Our Ref: 22/00706/FULHH

PROPOSAL: Proposed first floor extension and single storey extension to rear and to front facade.

LOCATION: 9 Railway Street Manningtree Essex CO11 1DS

EXISTING PLAN AND  
ELEVATIONS

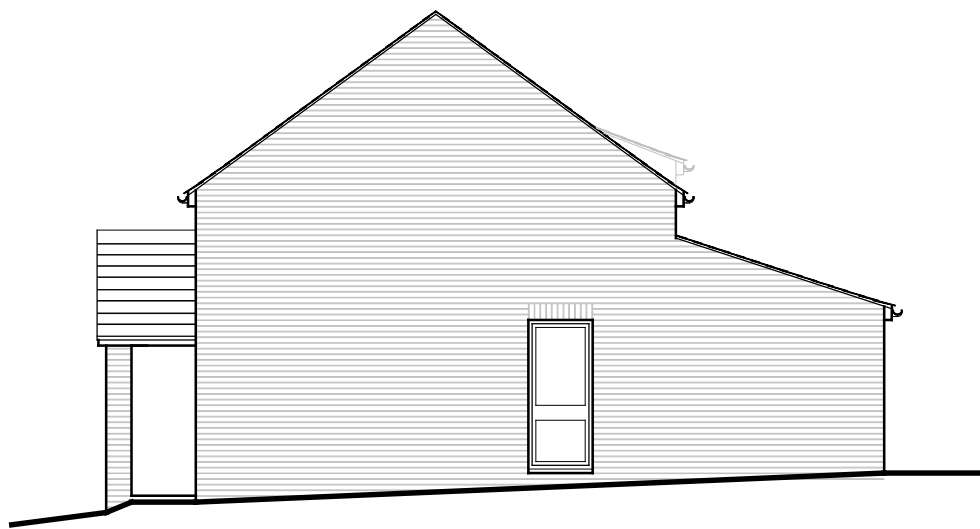
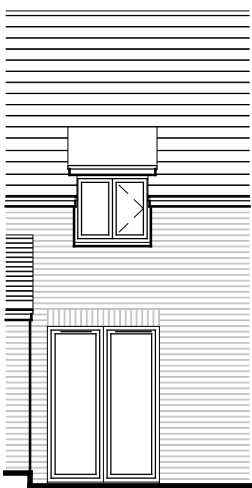
It would be useful if you could please provide a elevation of the other side as existing. Please ensure this plan is to a scale of 1:100.
